5384
CB

Drafted 10 April 2012

**Planning Application, Ribble Valley District
D3-12-0287 McDonald's Restaurants Ltd, RV Enterprise Park, Barrow**

PLAN VIEW 1/20

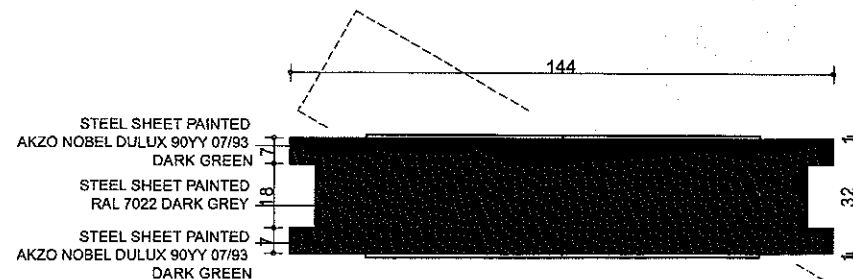
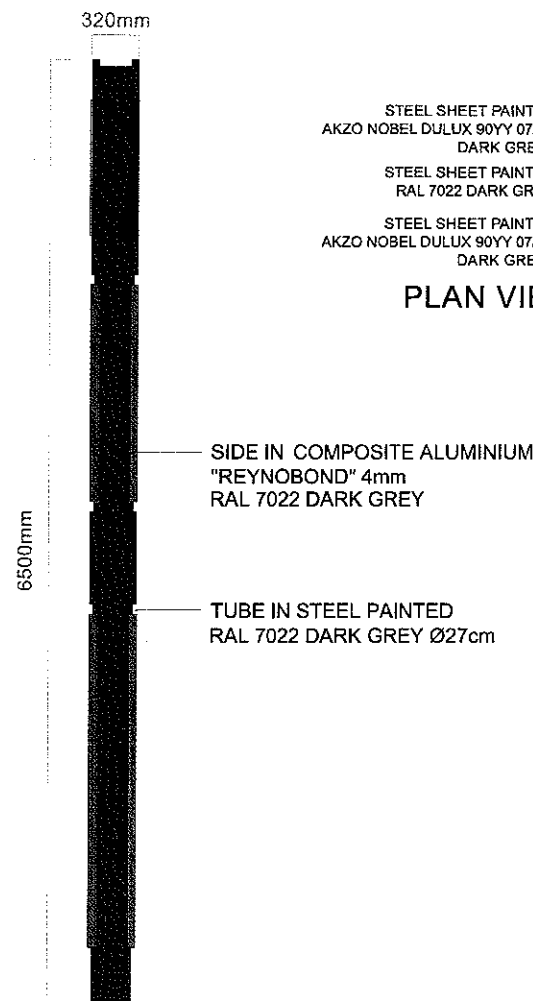
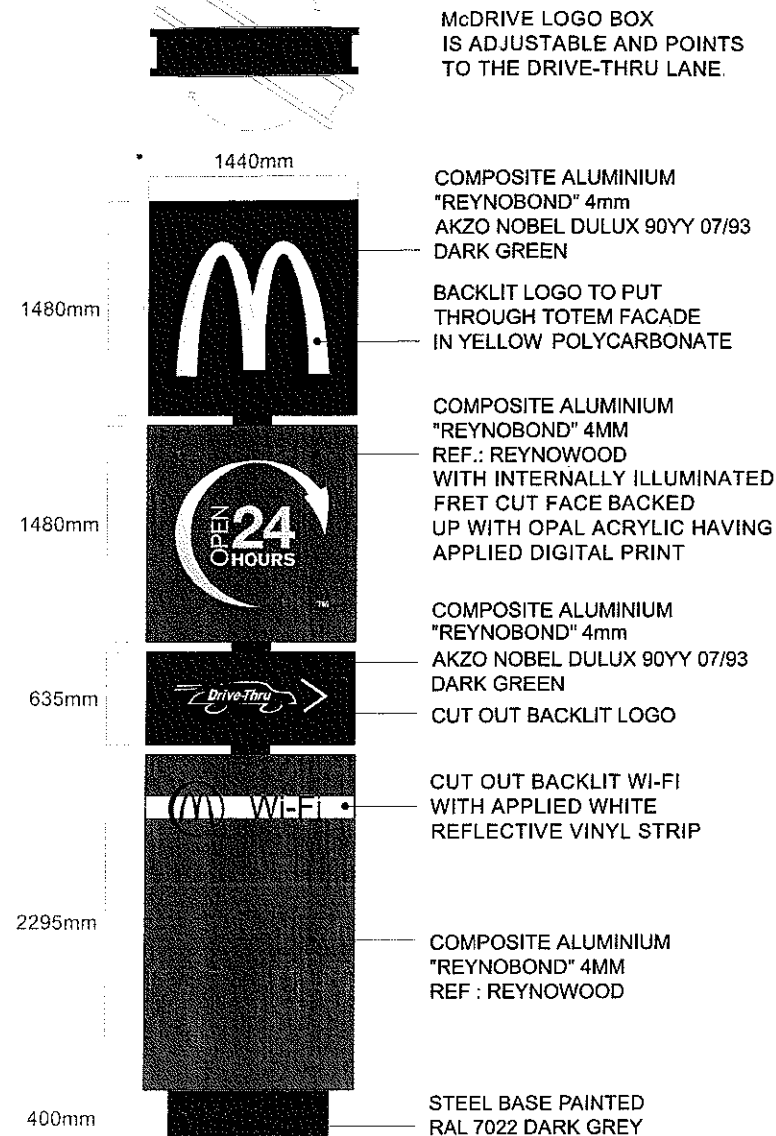
Therefore, it would be helpful to have an additional drawing(s) showing the height of the 6.5m totem relative to the carriageway and its impact in relation to the access to Ribble Valley Enterprise Park.

DRAWING TITLE :-
Block Plan
APPLICATION 2- TOTEM 6.5m

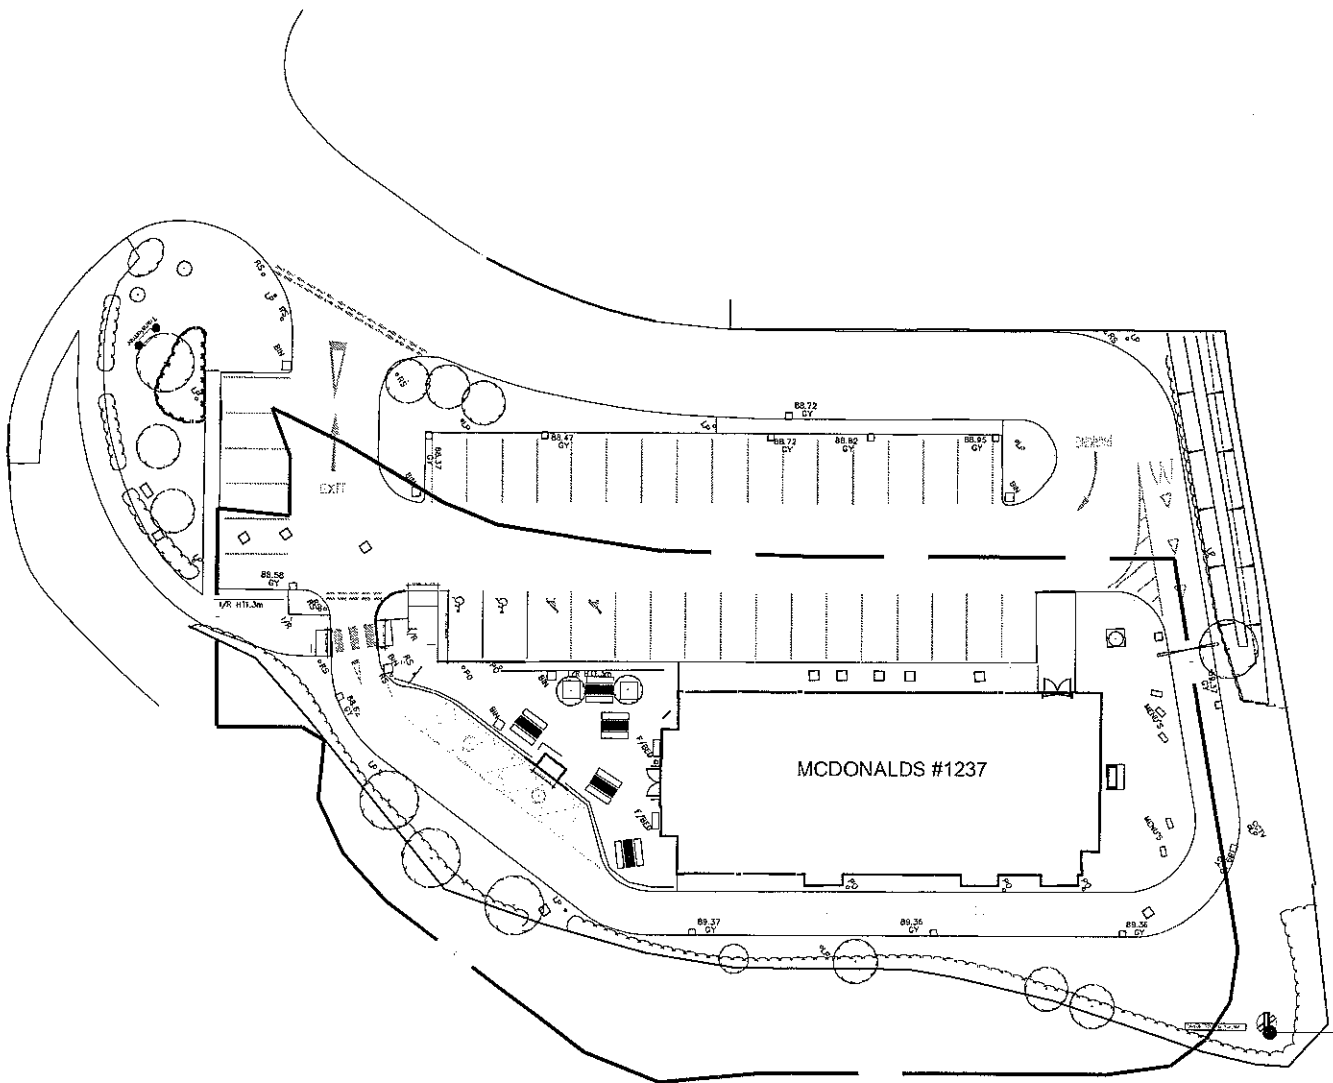
The proposed totem is to be placed at a site that is set significantly below the adjacent road level. In addition, the existing totem is located some distance from the entrance to the restaurant site. However, it does not provide the significant visual impact of the proposed larger sign, which I consider could be misleading for approaching motorists. Any confusion or potential misdirection at this location on the A59, where motorists are manoeuvring through a complex road junction, must be avoided.
